Our ref: HA/2025/126636/01-L01
Your ref: M/22/25/PL

DEMOLITION AND ERECTION OF 1 NO DWELLING. THIS APPLICATION IS IN CIL ZONE 4 AND IS CIL LIABLE AS A NEW DWELLING.

86 ANCTON WAY MIDDLETON-ON-SEA PO22 6JP

Environment Agency position

Drawing status
PLANNING
Drawn by
PP
Drawing Number
004

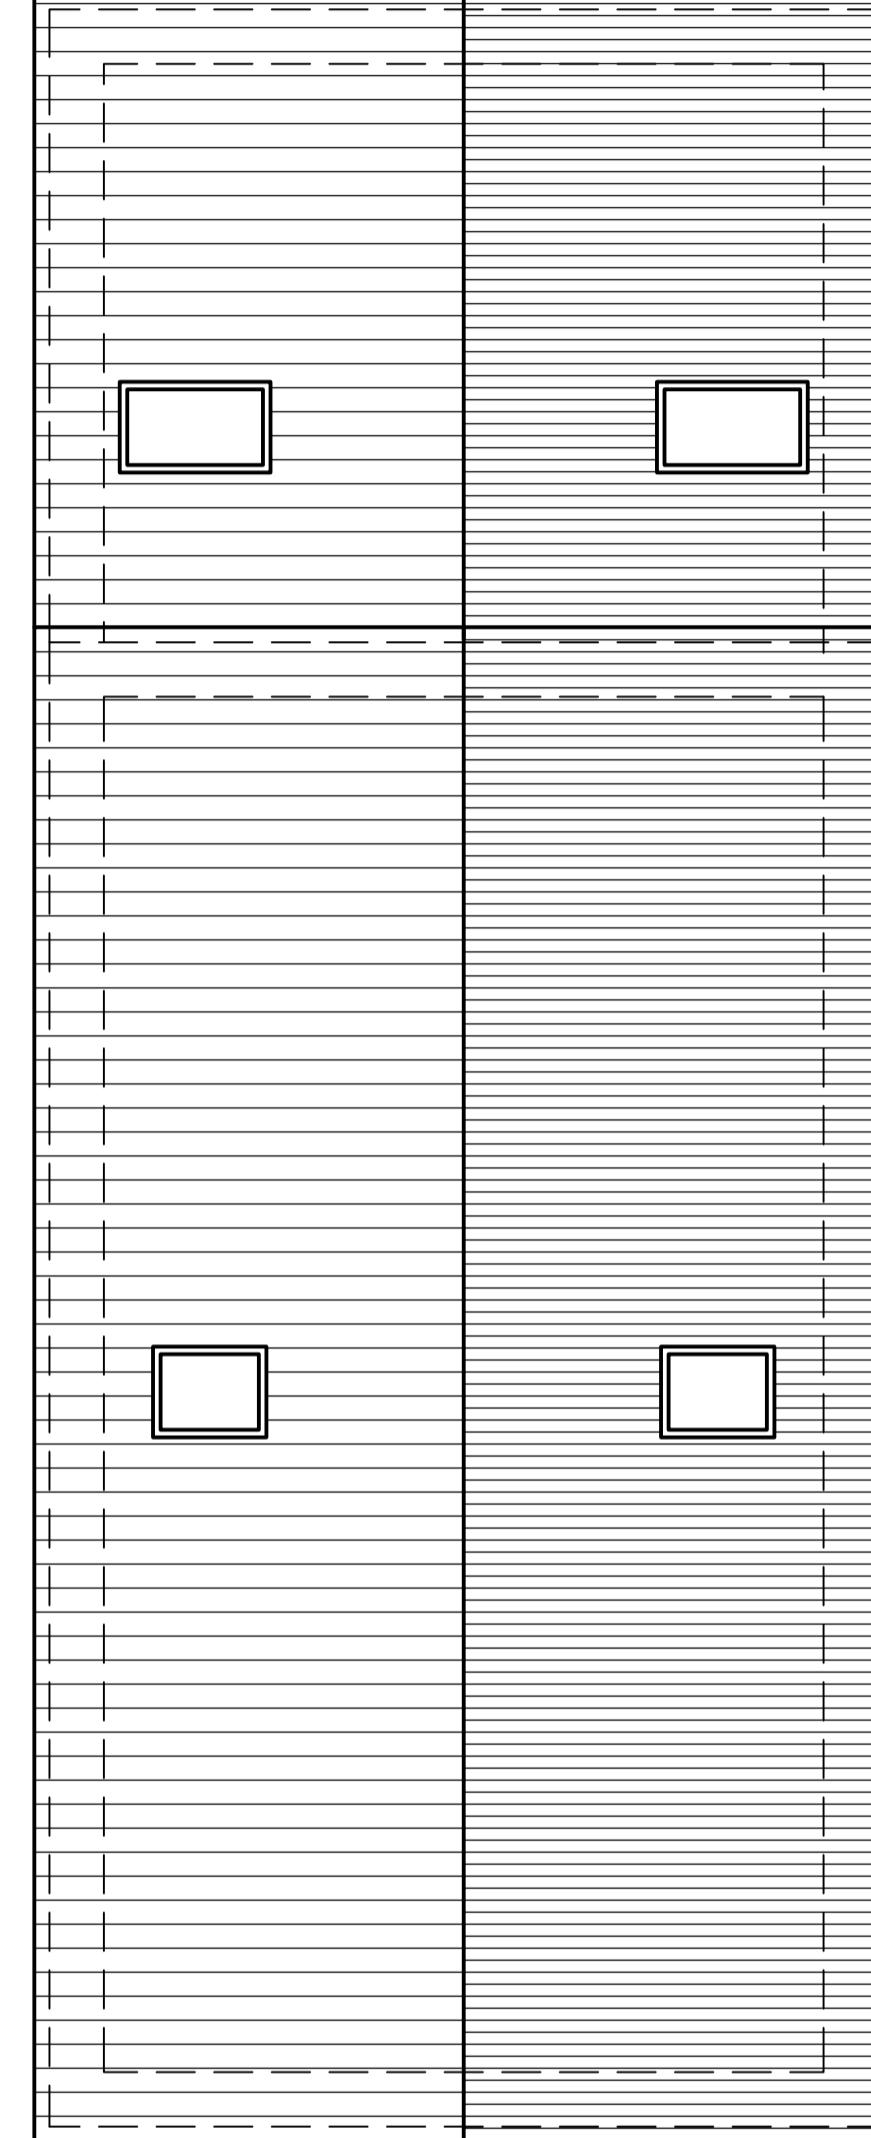
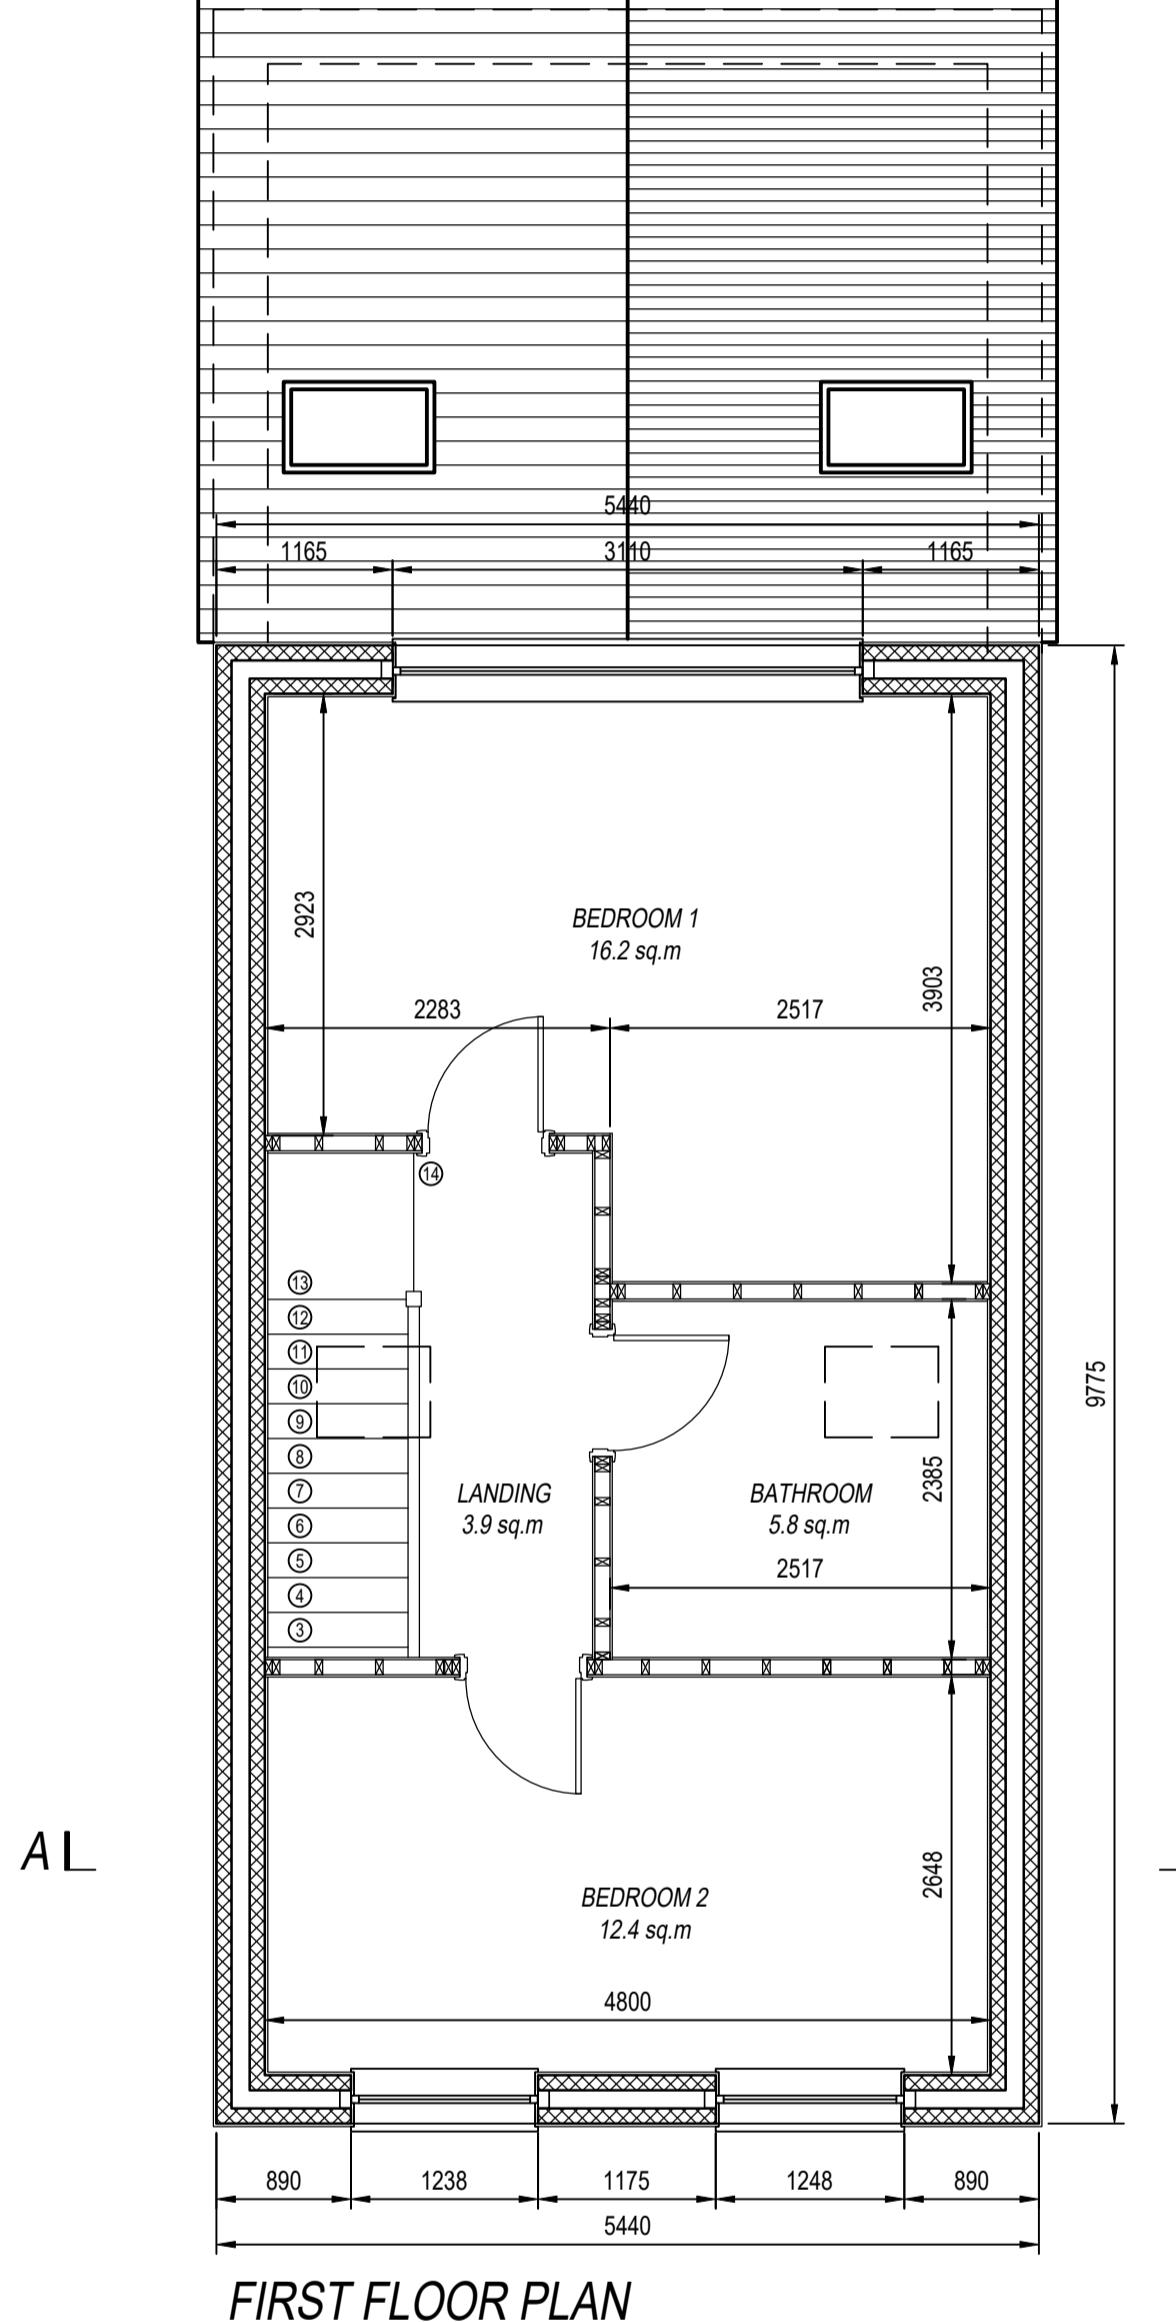
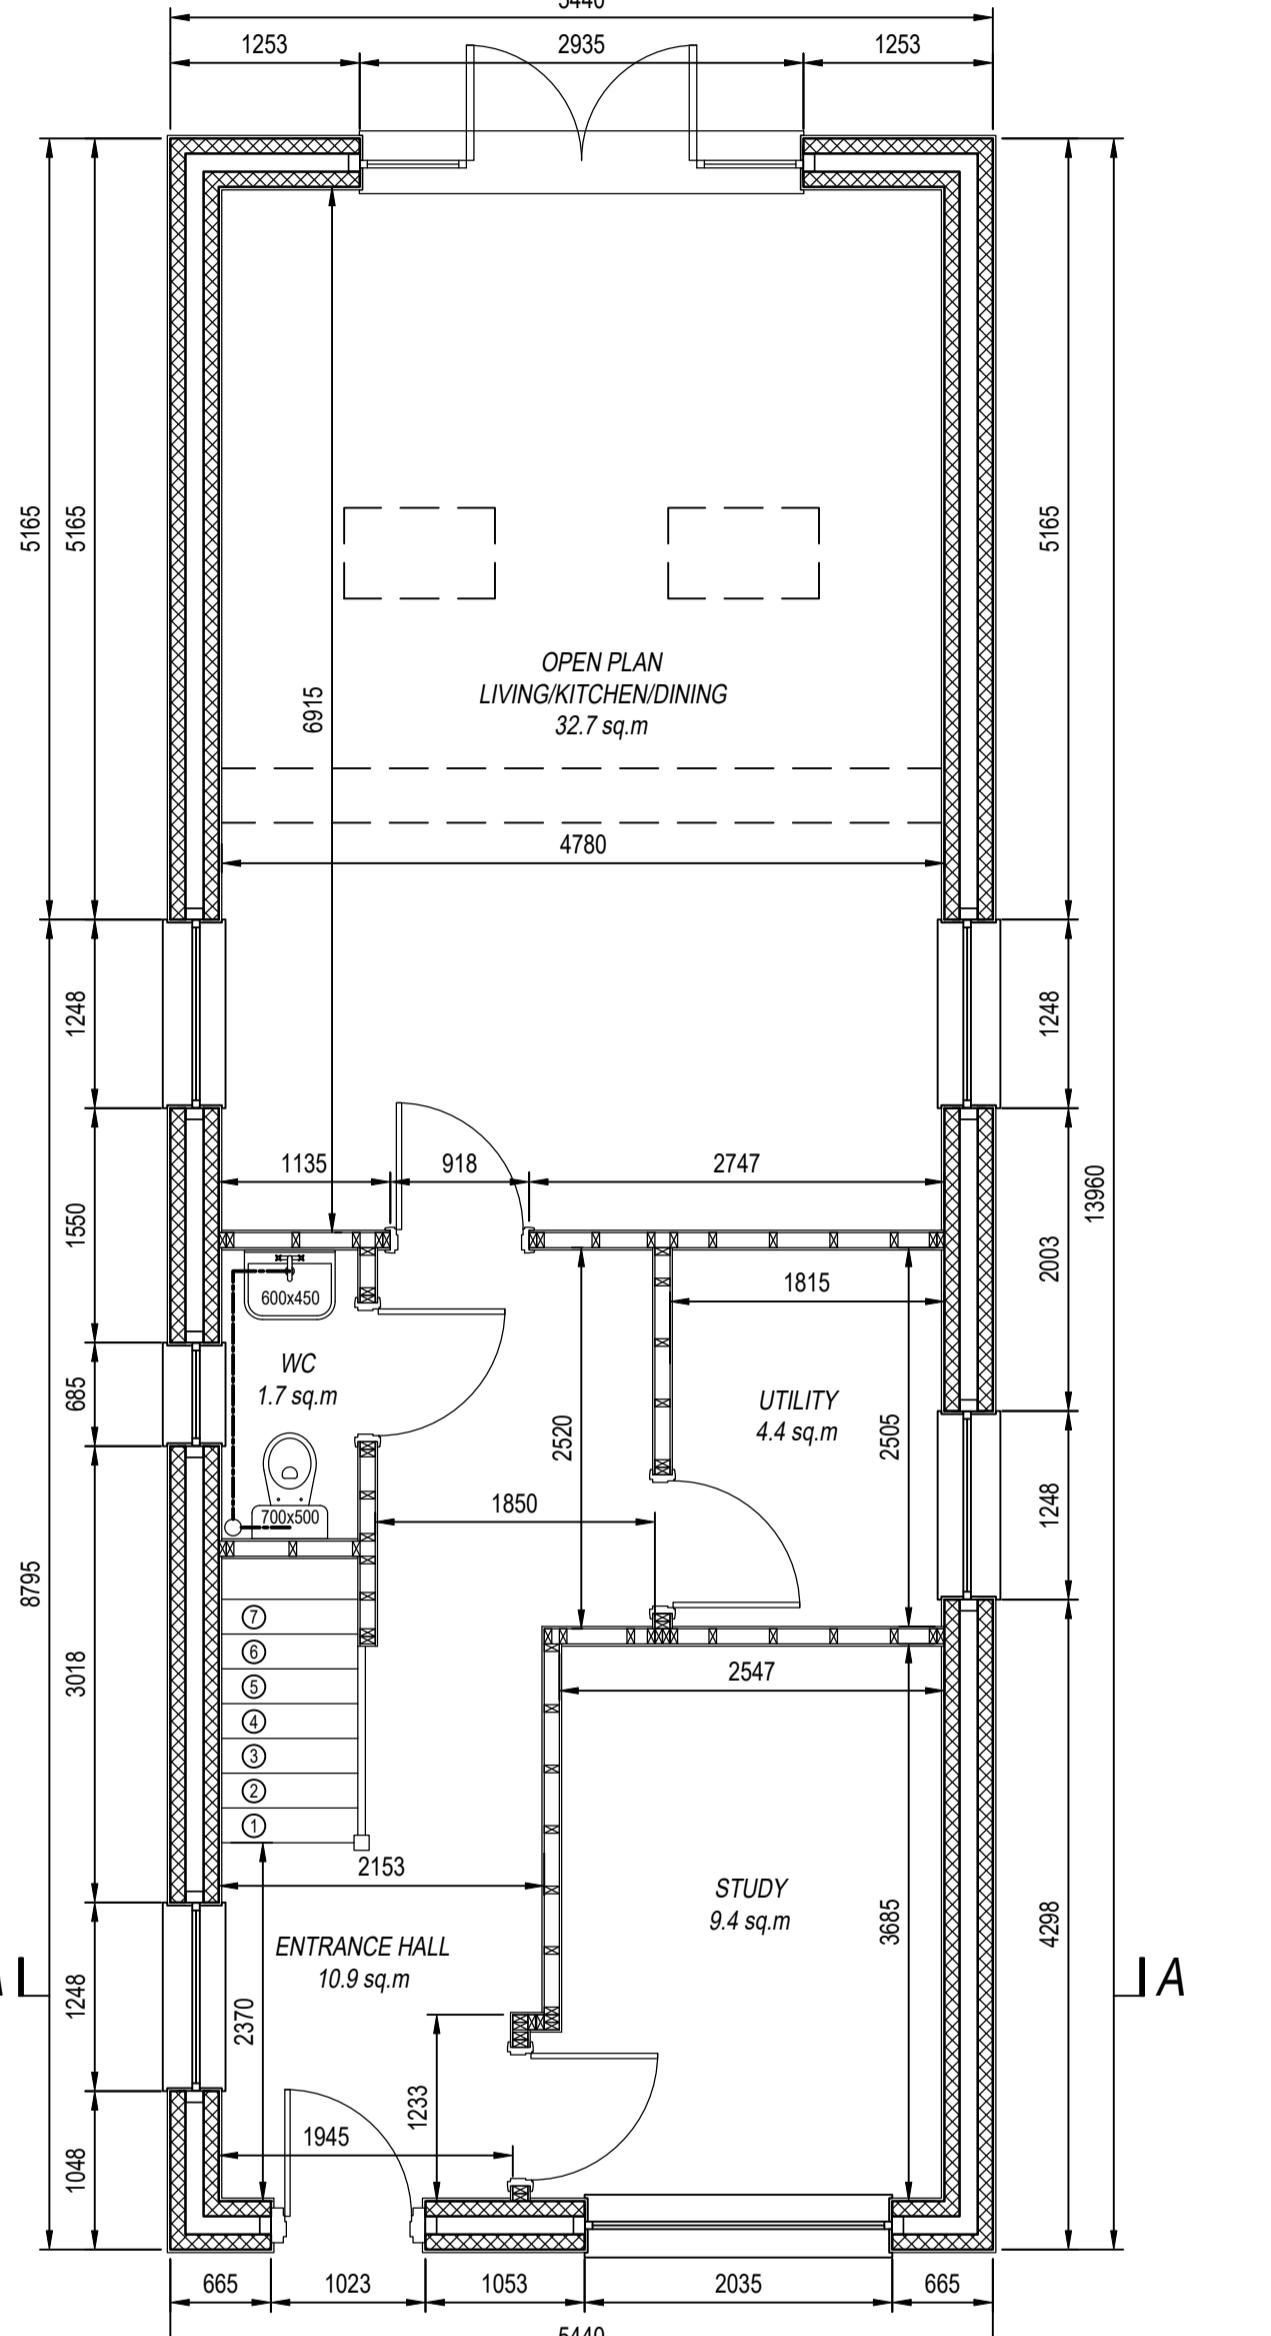
- Finished floor levels shall be set no lower than those of the existing property
- Flood resistant constriction should be used as set out in 2.9.2 of the submitted FRA. This should include air vent covers and either specialist manufactured flood-resistant doors or flood barriers.
- There shall be no sleeping accommodation on the ground floor as shown on drawings 004 rev PL4.
